**WELWYN HATFIELD COUNCIL – DEVELOPMENT CONTROL**  
**DELEGATED REPORT**

<b>APPLICATION No:</b>	<b>S6/2010/134/FP</b>
------------------------	-----------------------

The application seeks full planning permission for a new boundary treatment along Woodfield Lane which borders the existing car parking area to Twelve Apostles Church.

WOODFIELD LANE ELEVATION
PROPOSED NEW RAILINGS
1:75

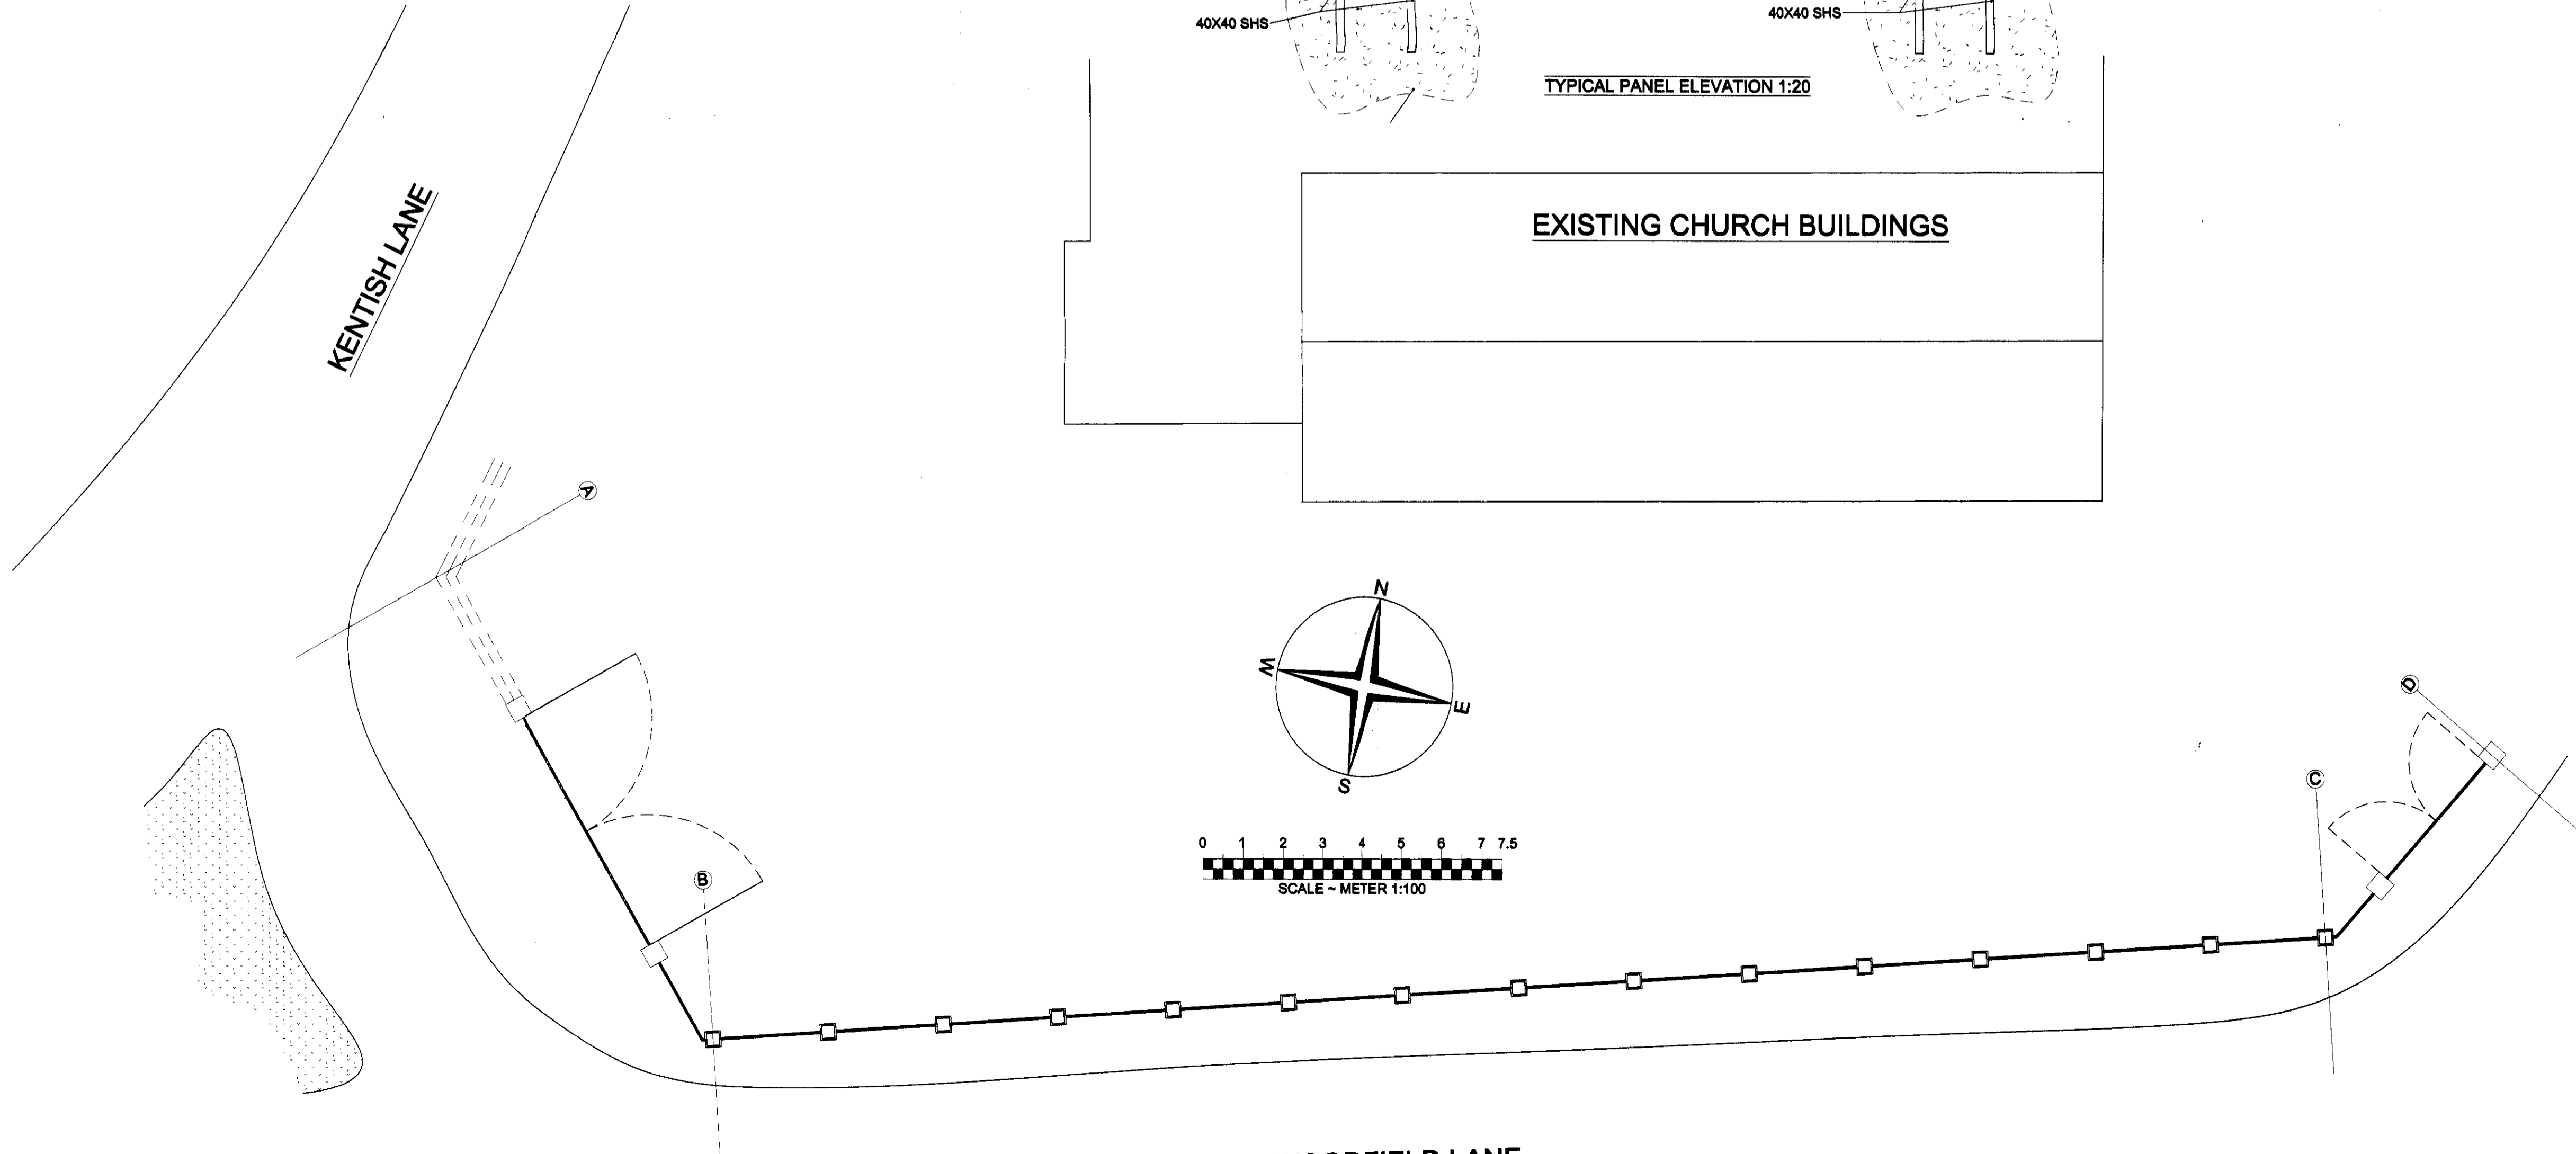
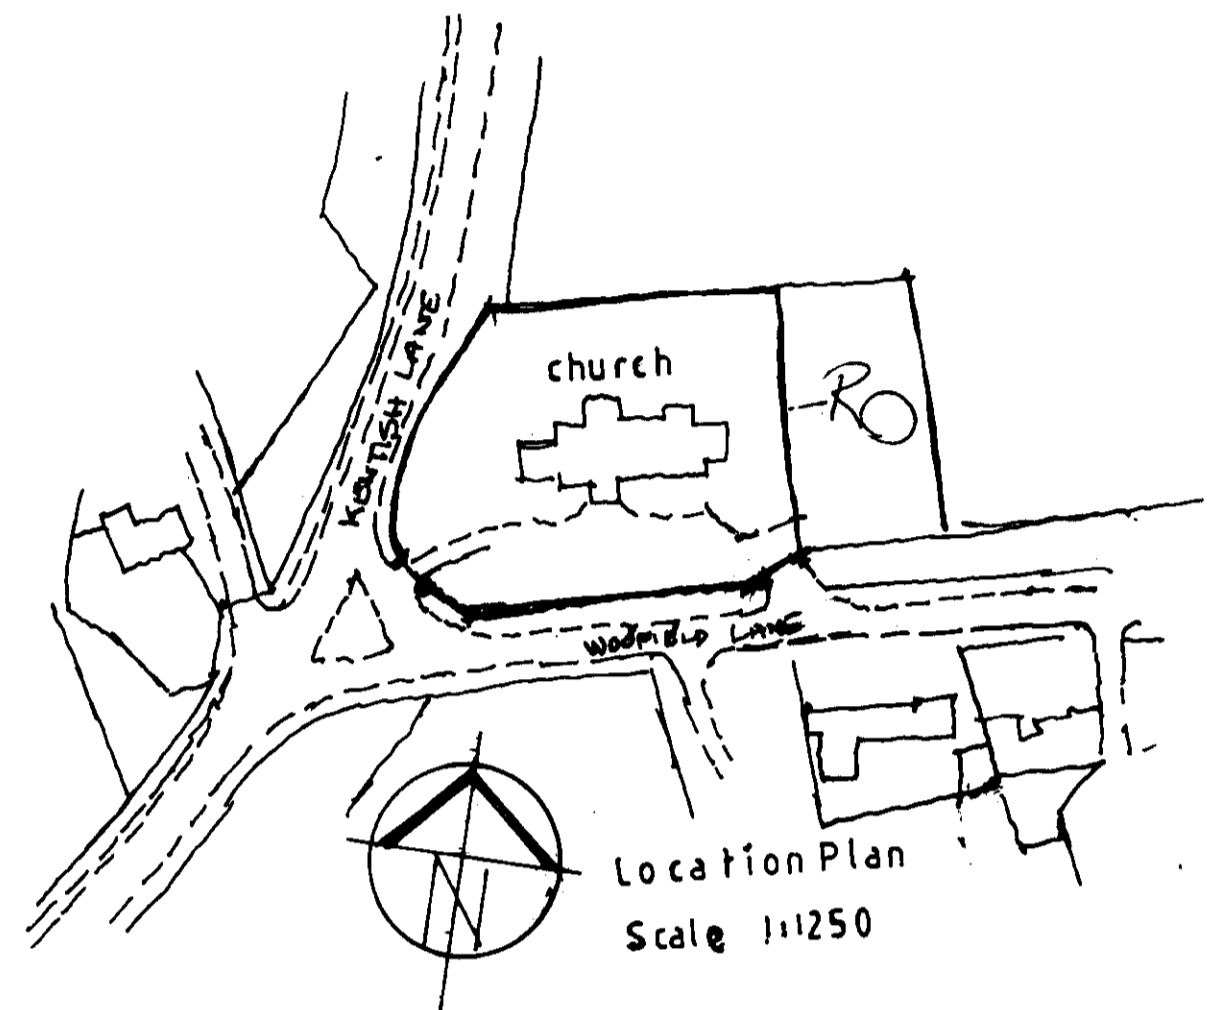
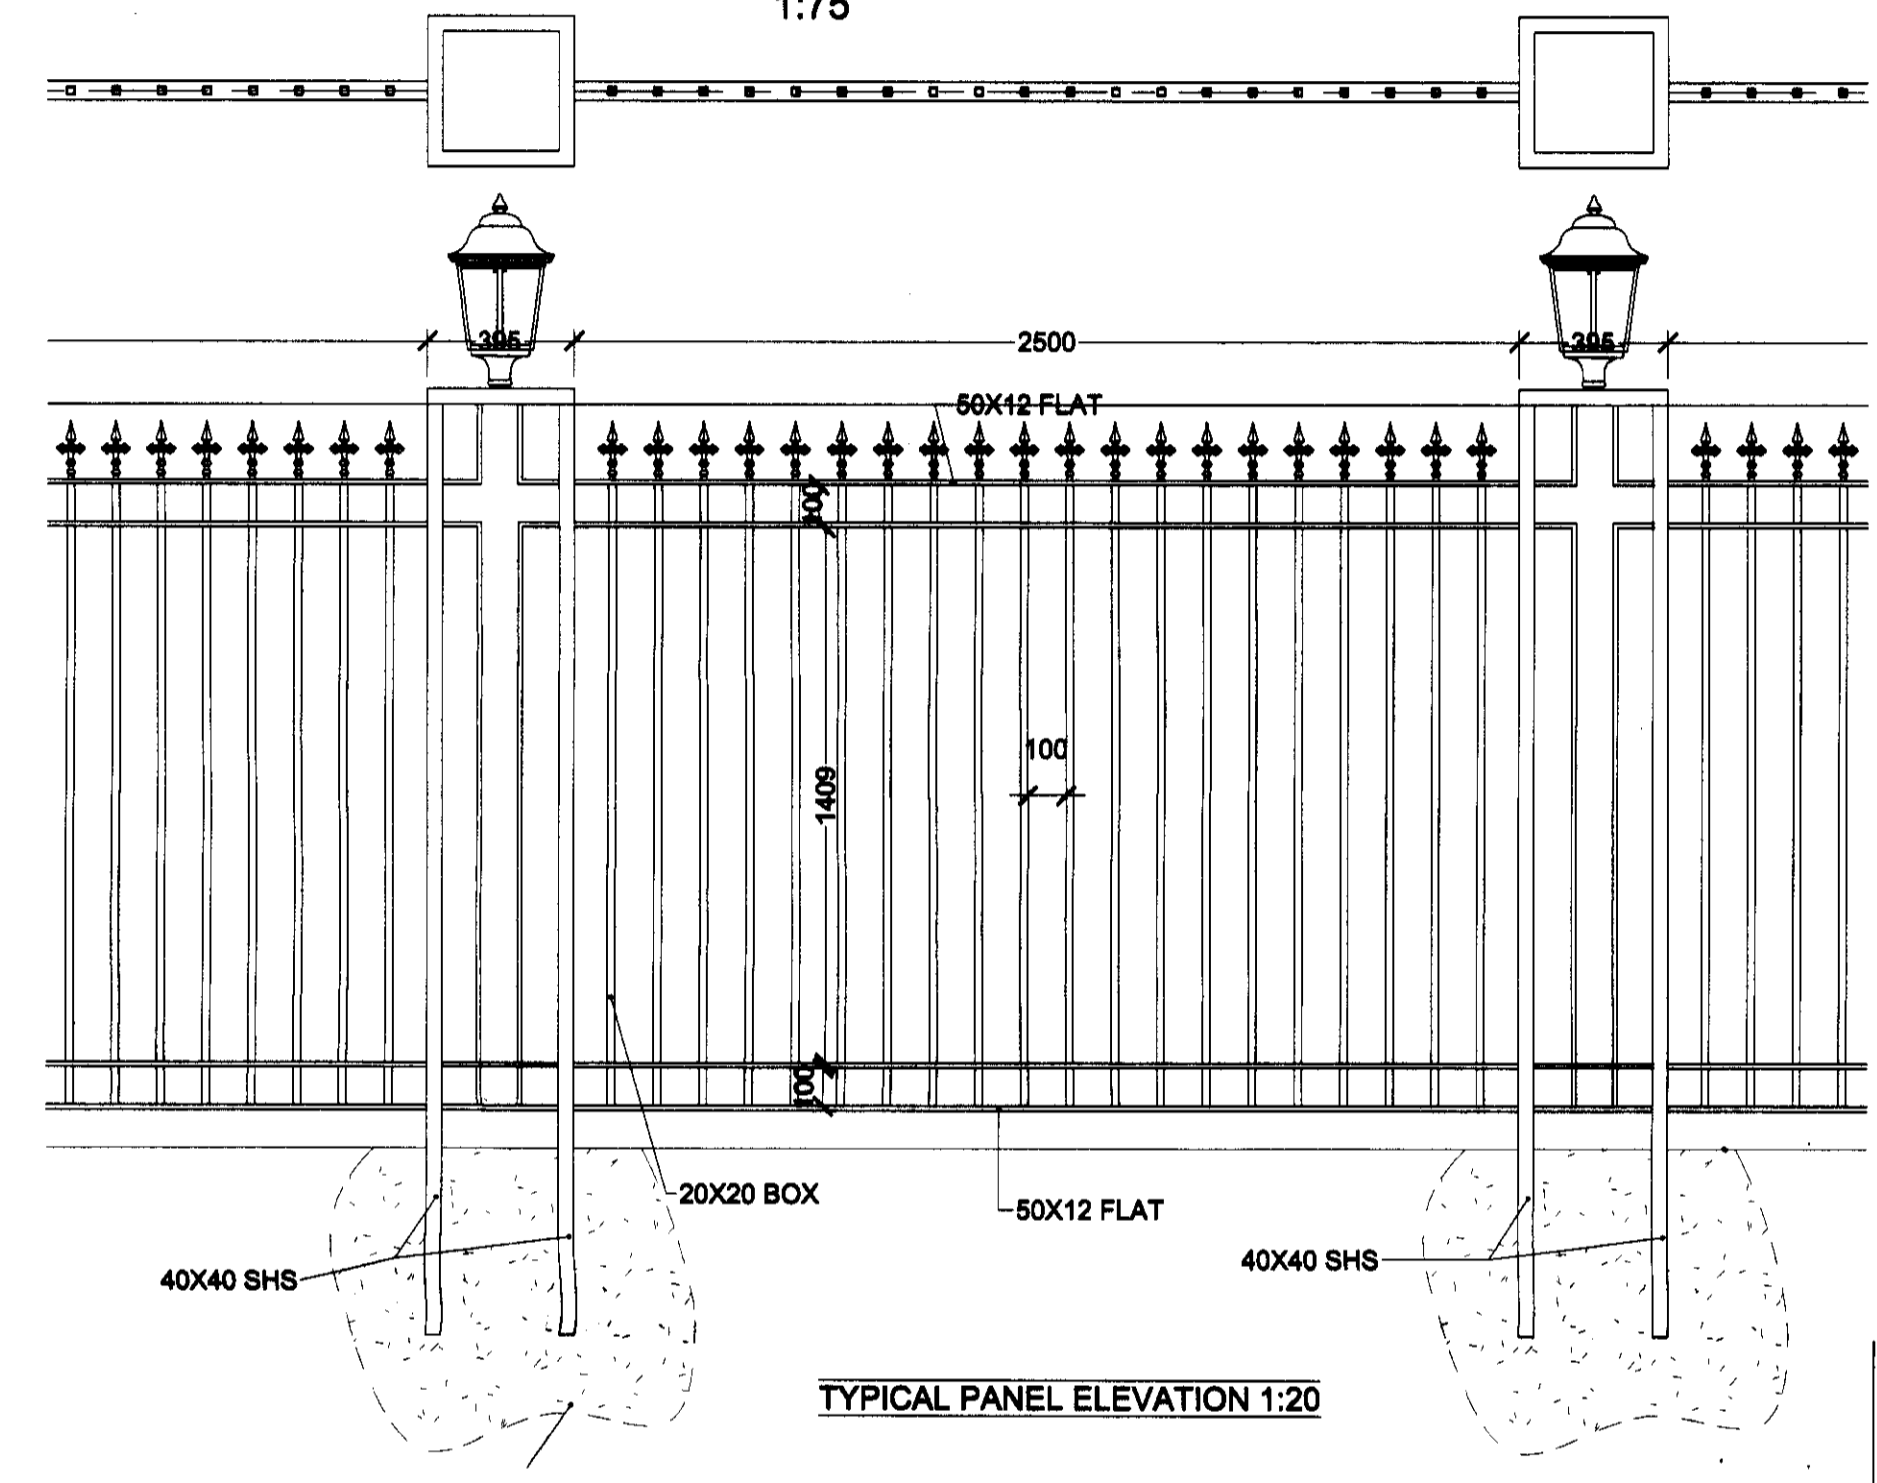
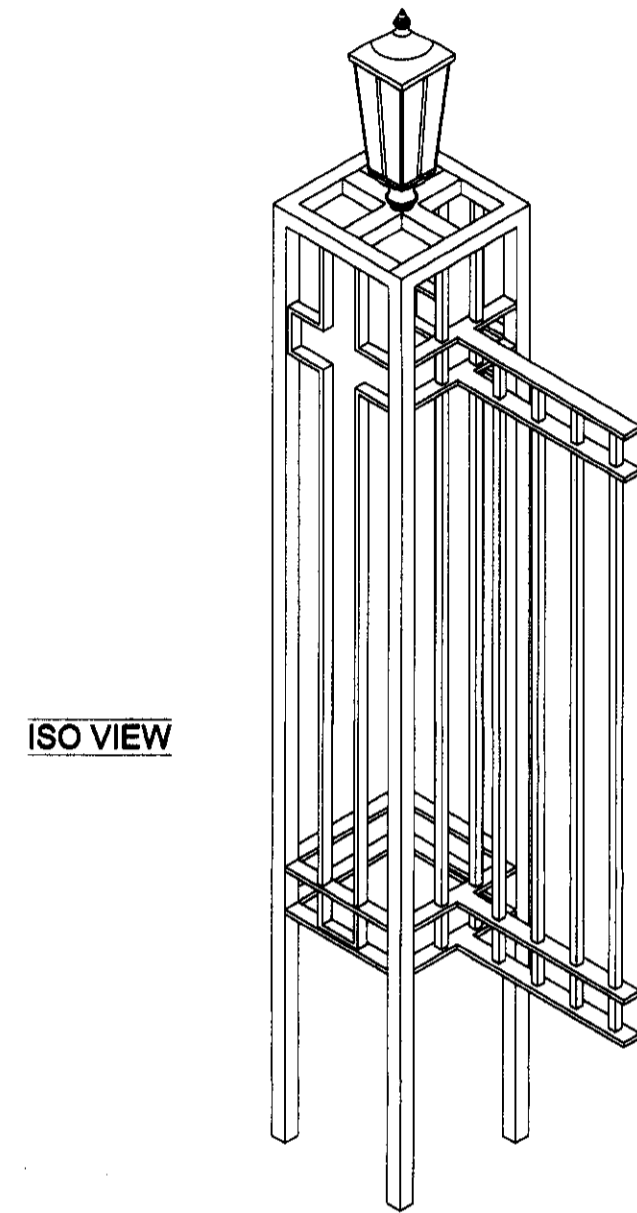
Due to the location of the proposed railings being very close to the highway and the substantial increase in height, it is considered that the impact on the visual amenity of the Green Belt would be harmful as it would be visually intrusive. Although the new proposal would allow views through the railings to the church beyond, which is an improvement on the perceived openness of the Green Belt, these benefits are then lost due to the substantial increase in height which would make it much more conspicuous and harmful to the visual amenity of the area.

Policy D1 requires an assessment of the quality of the design to be made. If the design of the railings are taken in isolation of their context and setting, then the appearance of these would be acceptable. Some detailed thought has gone into the design of these which shows an ecclesiastical reference with the columns show a cross like feature.

These concerns along with the proposed design and appearance are also relevant in regards to Policy D2. The current boundary treatment is made up of broken flint, with a red brick shaped copping. These materials replicate that used on the church building and both may have been constructed at the same time. These materials form part of the important character of this immediate locality and although black painted metal gates already exist, the size of these do not overwhelm this established character.

The proposed extensive use of railings would be alien in this context to this site and their significant height would particularly harm the character of this site which currently benefits from being open and so allowing unobstructed views to the church behind.

The proposed lanterns (the application form does not refer to lighting and so it is assumed they are not lit), also gives a very urban character to these railings. The overall result would be an alien feature in this rural location.

1. The proposed development would represent inappropriate development in the Green Belt which would be harmful to the openness of the Green Belt and detrimental to its visual amenity by virtue of its height, siting, materials and design contrary to the requirements of Planning Policy Guidance Note 2 (Green Belt). There are no very special circumstances which have been advanced to justify a departure from the Green Belt Policies of restraint.
2. The proposed design of the railings would fail to relate and respect the character and context of this rural locality and landscape due to the excessive height, design and proposed use of materials and so would be contrary to the requirements of Policy D2 & RA10 of the Welwyn Hatfield District Plan 2005.
